Final Plat OWL RIDGE SUBDIVISION

PART OF THE WEST HALF OF THE SOUTHWEST QUARTER OF SECTION 7, TOWNSHIP 11
SOUTH, RANGE 65 WEST OF THE SIXTH PRINCIPAL MERIDIAN
COUNTY OF EL PASO, STATE OF COLORADO

DATE SUBMITTED: 01/20/2023

Final Plat

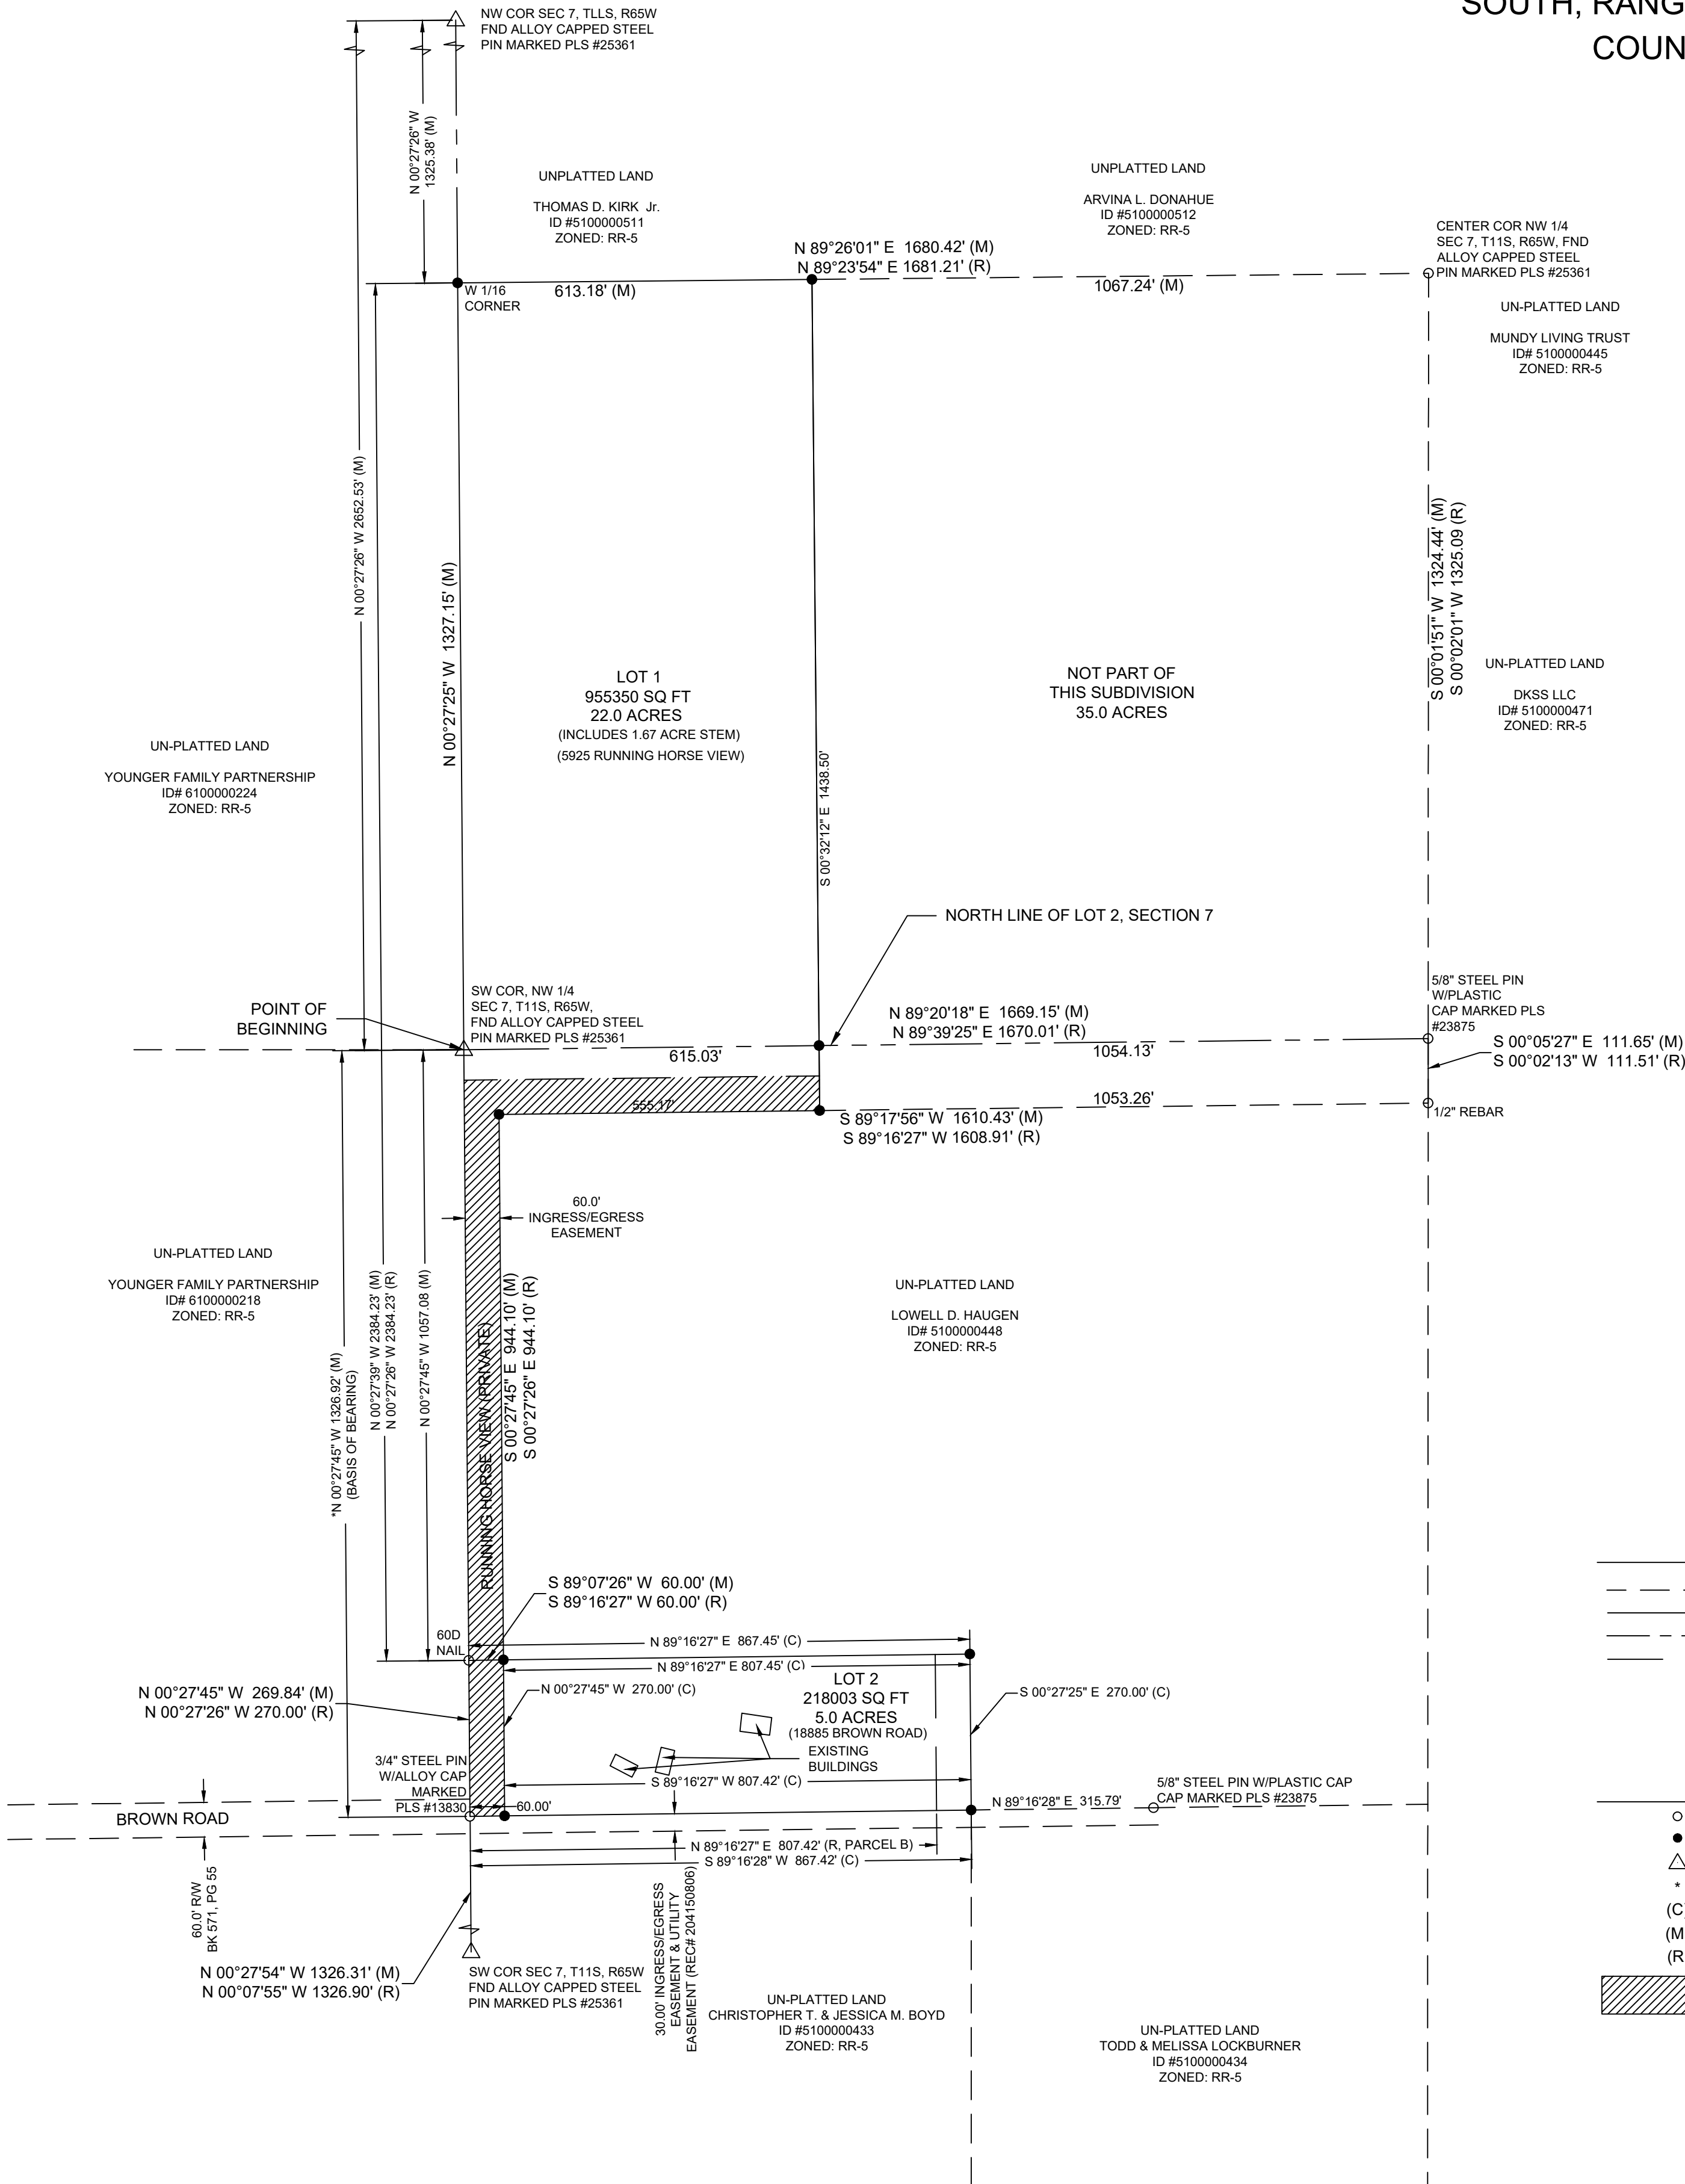
Unresolved comment:
This needs to be included in this subdivision as Lot 3. It is part of the parent parcel and is subject to this subdivision request.

Unresolved Comment
All this data needs to be updated to include the 35 acre lot as well
